**Havering**  
LONDON BOROUGH

6<sup>th</sup> July 2021

**London Borough of Havering (20025659) London Borough of Havering Response to Updated Draft Development Consent Order (REP9-058)**

Notes:

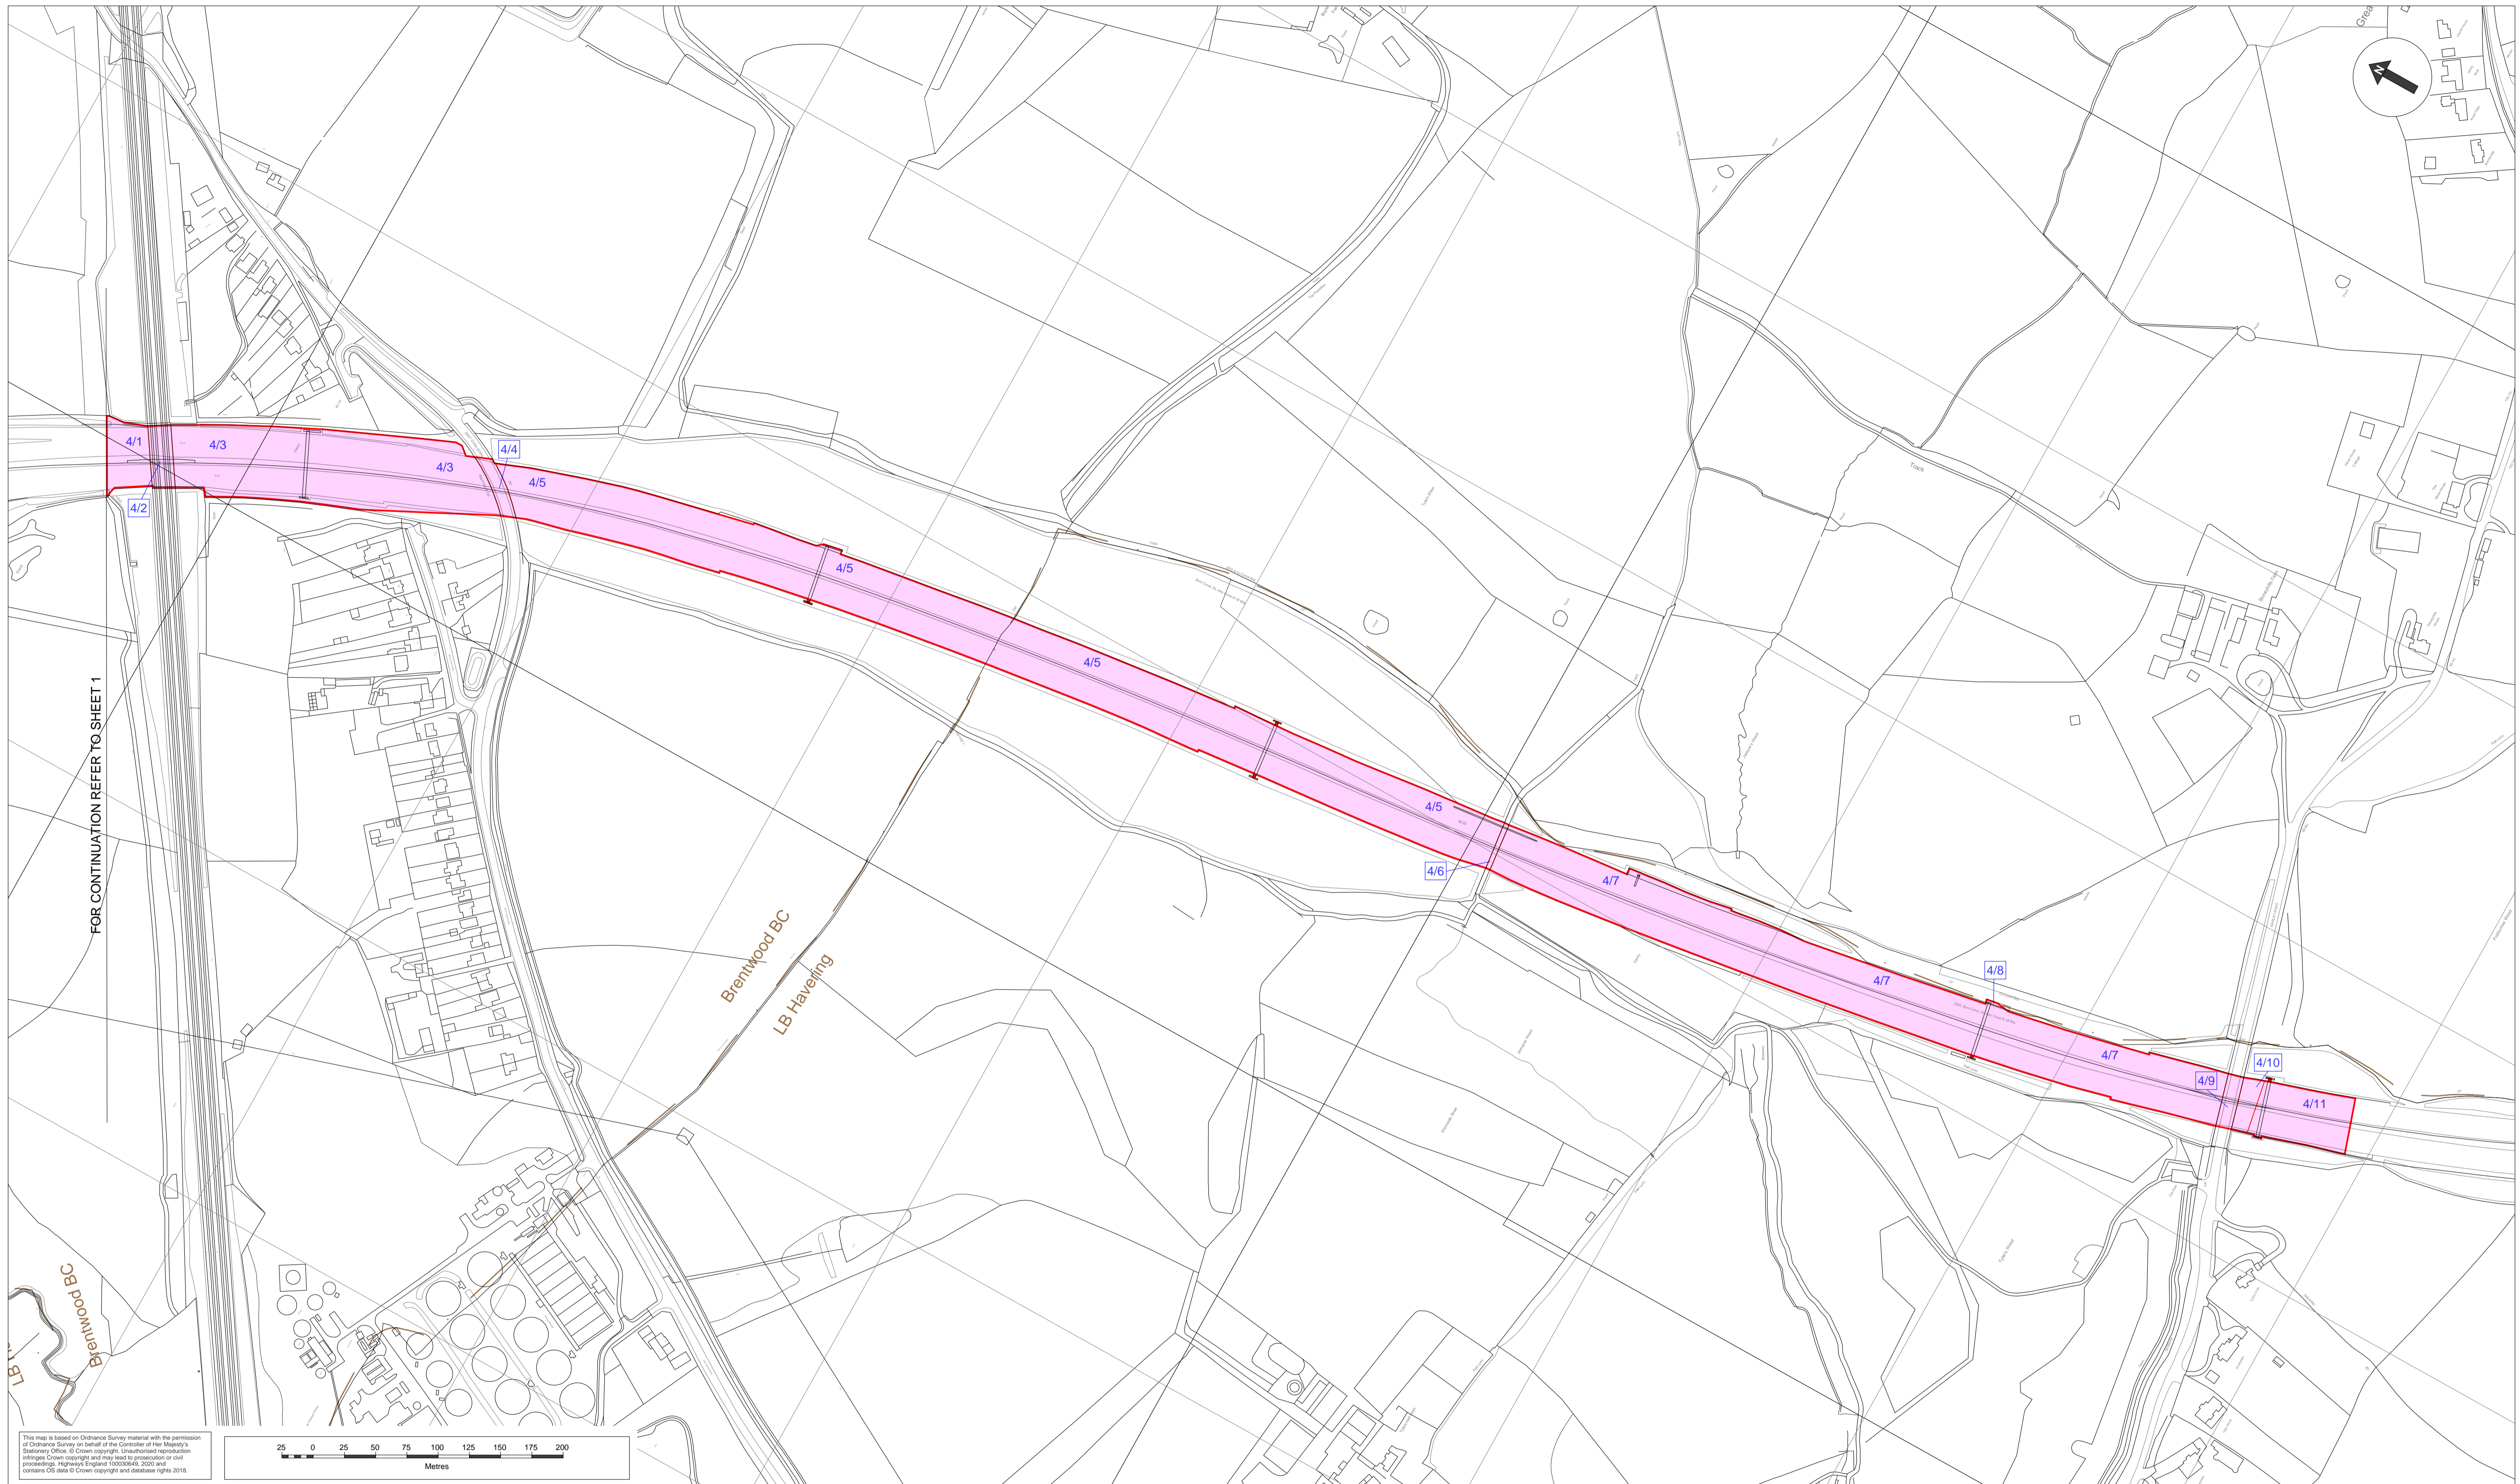
LB Havering notes that in Schedule 6 Article 28 1/25a that the installation, access, monitoring and maintenance of bird boxes is now included in the Schedule, and this is welcomed and supported. LB Havering notes that the provision of the fencing for the control of deer is not included in the land plans in Schedule 6. LB Havering requests that this is included in the relevant land plans.
